**Budokan Judo Club Inc Response to the Transport for NSW  
“Environmental Impact Statement (EIS) 2” dated 25th October 2012  
for the North West Rail Link (NWRL) Project**

This document responds to both EIS2 (SSI 5414) and also the Request for Modification of Staged Infrastructure Approval specific to the Castle Hill Station (SSI 5645 MOD1).

Figure 7.2 Showground Station site layout

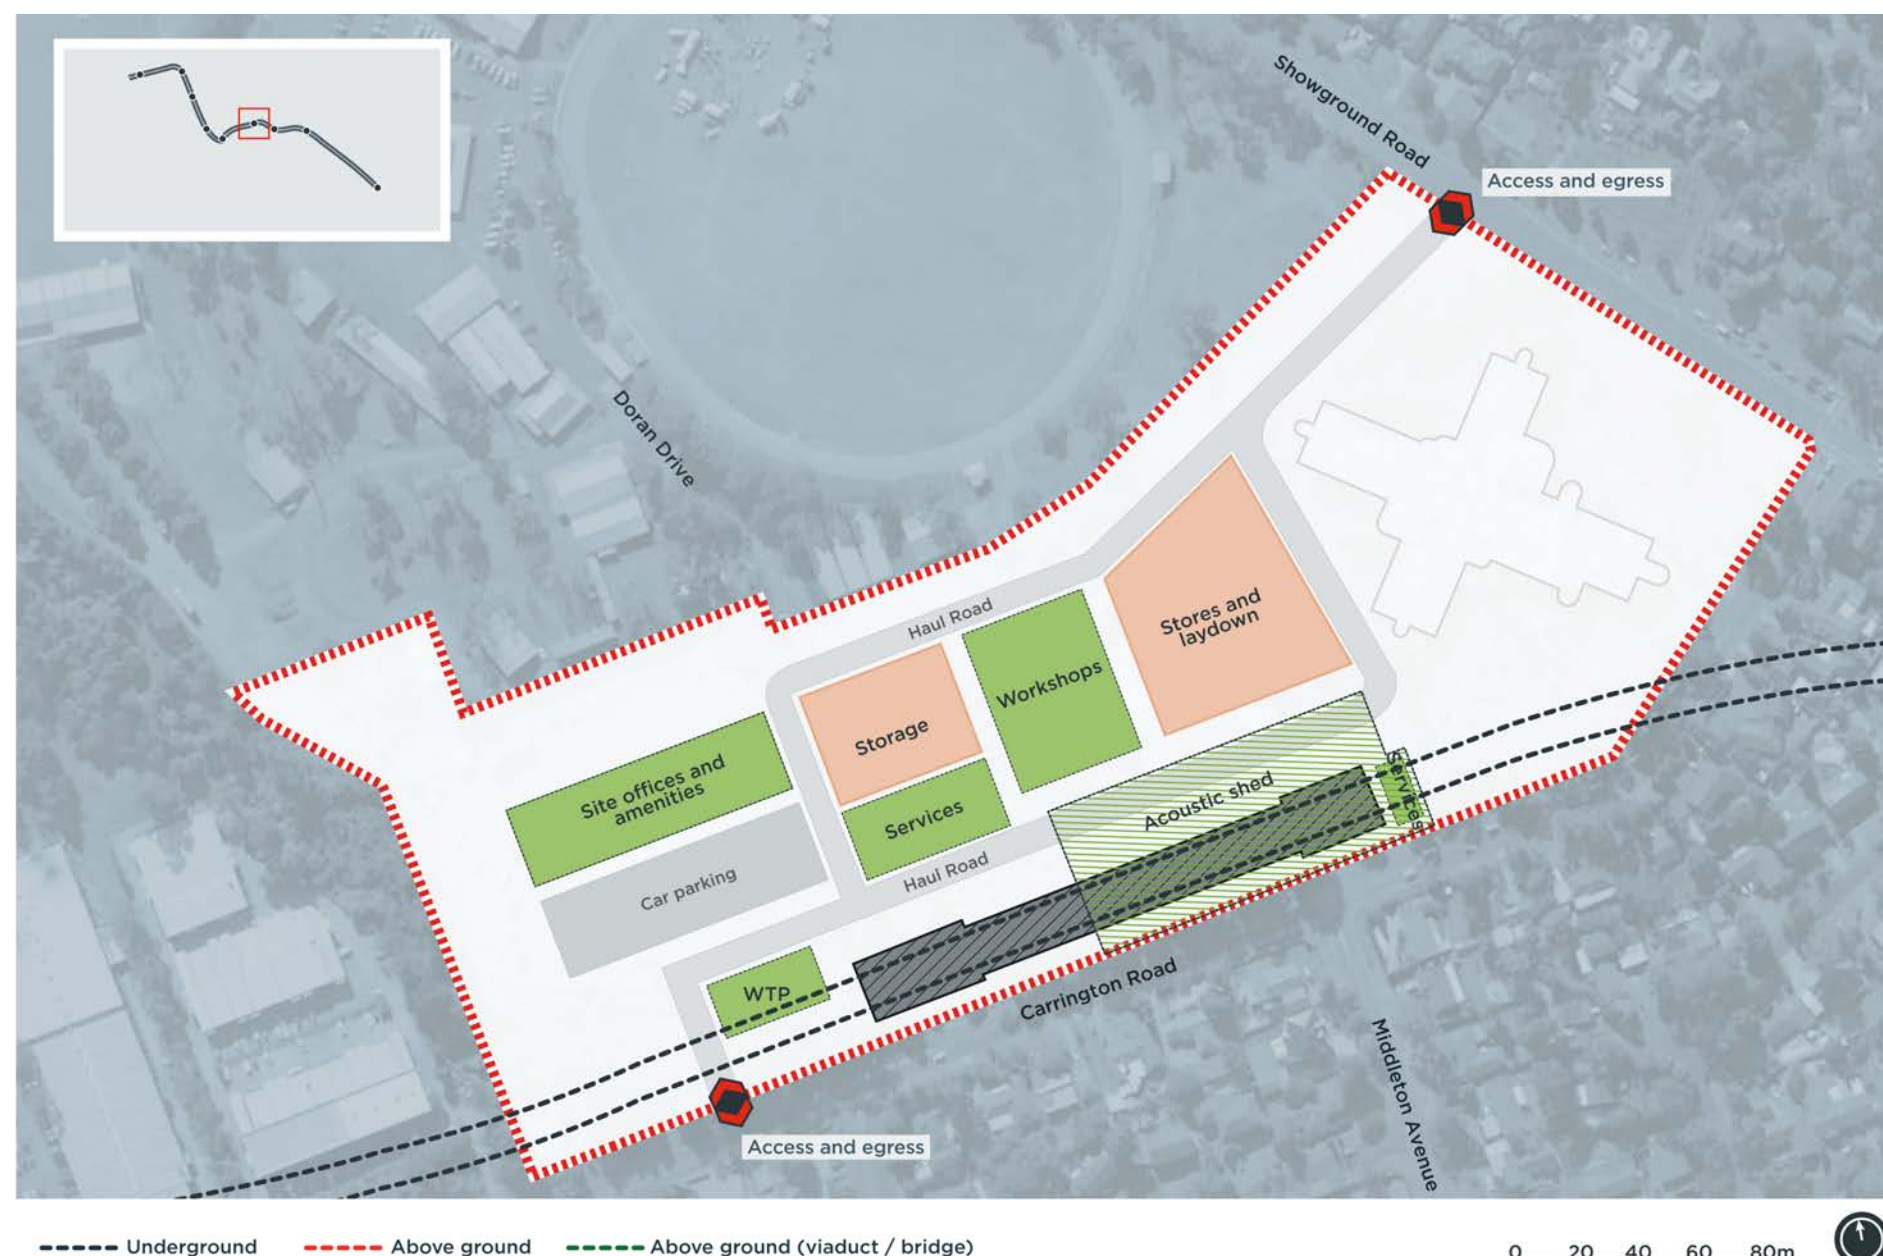
- 2) Budokan has been operating out of the Horticulture Pavilion of the Castle Hill Showground for over 15 years. The proposed Site Layout for Site 6, Showground Station in EIS2, indicates that the Horticulture Pavilion will be in close proximity to the proposed construction zone. Although now zoned on the Showground Station Precinct map as "Protected from construction impacts", risks both during and post-construction associated with the close proximity of the construction site to the Horticulture Pavilion have been identified and need to be satisfactorily managed.

Unclear from EIS2 whether construction traffic would be limited to the construction zone identified in EIS2 or whether construction traffic would be allowed to utilise the internal roads within the Showground that are outside the construction zone. Our members utilise the open space within the Showground (running) and the nearest public toilet facilities adjacent to the Showground. Our membership includes a significant number of children who would be at risk of construction traffic whilst attending and training at Budokan. Budokan seeks confirmation that Construction Traffic would be limited to the construction zone.

Management Plan". Budokan seeks confirmation that our members will be able to access the Horticulture Pavilion during the construction phase in a safe manner, ideally with access and egress quarantined from the construction site and construction-related traffic.

Unclear from EIS2 whether required parking for construction personnel would be contained within the construction zone. Given the immediate proximity of the Horticulture Pavilion (off Doran Drive) to the construction zone, there is a risk if parking is allowed outside of the construction zone, of access in terms of available parking within the Showground being restricted. The flow-on effect from inadequate parking within the Showground would be increased risk to children who may need to negotiate a congested parking situation to access for example the amenities block. Budokan seeks confirmation that parking required by construction personnel will be accommodated within the construction zone.
